Ivanhoe Estate Redevelopment – Stage 2 (SSD-15822622) RTS

City of Ryde Submission to RTS

IVANHOE ESTATE REDEVELOPMENT - STAGE 2

SSD-15822622

Figure 3 - Loading dock

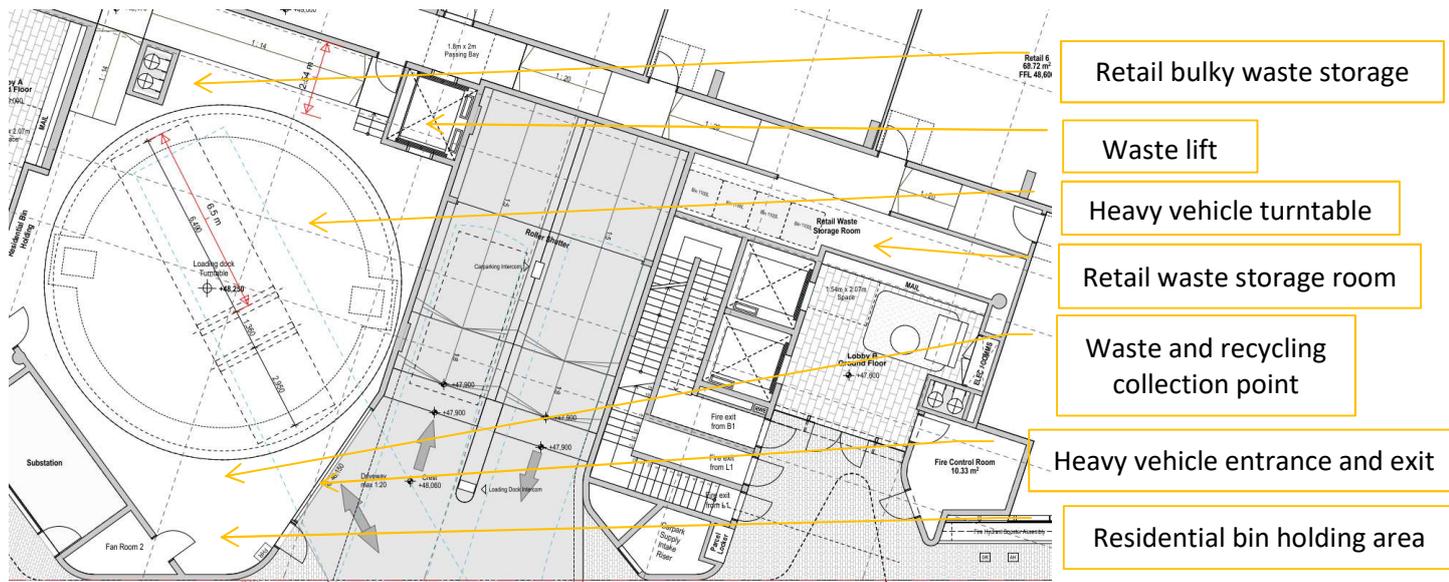
<p>The residential bin holding area at the rear of the Loading Dock Turntable is not large enough to house the above 19 bins – The loading dock area needs to be amended and the plans are to show the above bin configuration to ensure that they can be stored without impeding on the turntable area.</p>	<p>Further to the above, evidence has been provided of the increased bin numbers requested by Council that can be positioned around the loading dock area with ease. Refer to the Building C3 ground floor plan at Appendix C</p>	<p>As previously stated, bins cannot be stored around the turntable due to WHS and access issues. Storage of all bins awaiting collection needs to be provided in a bin holding room adjacent to the loading dock but well clear so that it does not impede the truck access and maneuvering. Council seeks that this matter must be full addressed by provision of additional space. A redesign is required.</p>

Figure 2 – Social waste storage areas on Basement 1

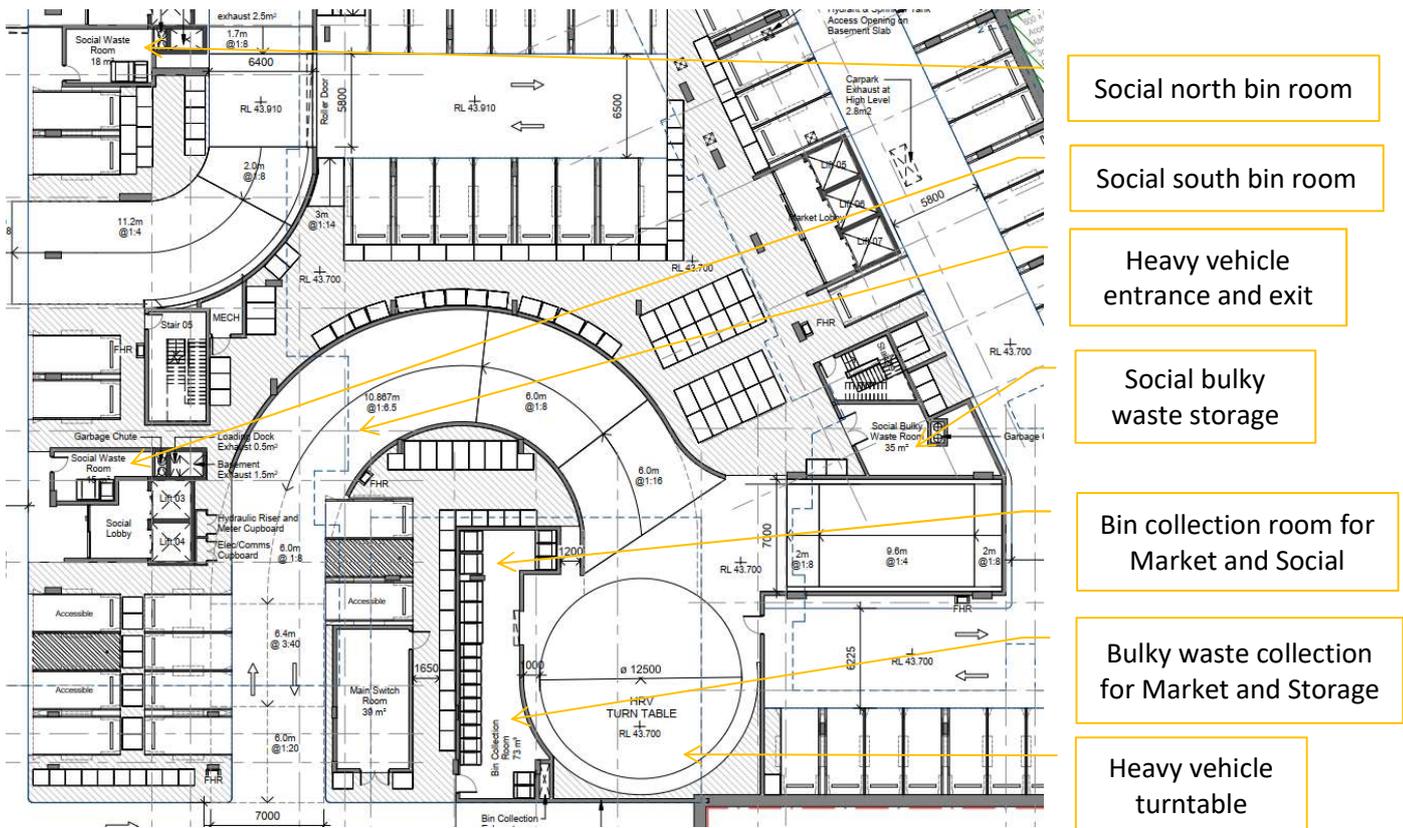
<p>There are dual chutes (one for waste and one for recycling) located on each floor of both Building A & B. The chute rooms on Basement 1 shows that waste will be compacted. Council does not allow for compactors due to breakage of the bins. The plans need to show that the above bin configuration can fit into the chute rooms.</p>	<p>No compaction will take place. The waste storage room detail shows bin conveyors in each case, not bin compactors. The submitted C3 Waste Management Plan (Appendix O of EIS) states on pages 7, 8 that no compaction is to occur.</p>	<p>Council is satisfied with this response</p>
	<p>The Bulky Waste Room is included as part of Building B waste store room. The bulky waste room needs to be a separate room so that access to the bins is not blocked and residents do not access the chute room. Plans need to be amended to provide a separate bulky waste storage room. It is suggested that the Bulky Waste Room is located on the ground floor adjacent to the loading dock to provide a more efficient service. Safe access for residents is to be considered when relocating the bulky waste storage room. This will be more efficient for the building manager in not being required to move the cleanup items from the Basement to Ground Floor.</p>	<p>Two (2) bulky waste rooms have now been provided. Refer to the Architectural Plans by Fox Johnston at Appendix C. These cannot be located on ground level due to the loading dock, substation, residential lobbies and retail uses that are required to activate the park and street frontages.</p>	<p>Council confirms that the 2 bulky waste rooms are adequate for the number of units albeit on the basement level.</p> <p>Location of where the bulky waste material will be stored awaiting collection from the loading dock is required.</p> <p>The Waste Management Plan needs to be updated to show how the bulky waste material will be taken up to the loading dock for collection. This matter is still unsatisfactory and will impact on the waste collection.</p>

<p>There are 3 dual chutes (one for waste and one for recycling) located on each floor - 2 for social but only 1 for market</p>	<p>The documentation appears to have been misinterpreted. Two chutes continue to be provided for both</p>	<p>The Waste Management Plan only shows one chute room for Market and the other chute room seems not to have been provided on the plans. Please provide the location of the 2nd chute on the plans.</p>

The Bulky Waste Room for Social is located on Basement 1, with the Waste Chute for Market running through it to the basement 2. It is suggested that the storage room for bulky waste is located adjacent to the loading dock to provide a more efficient service thus meaning the building manager will not be required to move the cleanup items. Safe access for residents is to be considered when relocating the bulky waste storage room.	Significant design development has been undertaken with various engineers to achieve a viable configuration for the ramp and loading dock. As a result, there is a limited space adjacent the loading dock to locate the social bulky waste room with for example, the main switch room required to be as close as possible to the substation above. Despite the various constraints, the social bulky waste room is located relatively close to the loading dock.	The social bulky waste room is shown on the plans as 35m2. Please advise the distance from the room to the loading dock and advise where the material from the Market bulky waste room will be taken for collection on Basement 1 from Basement 2
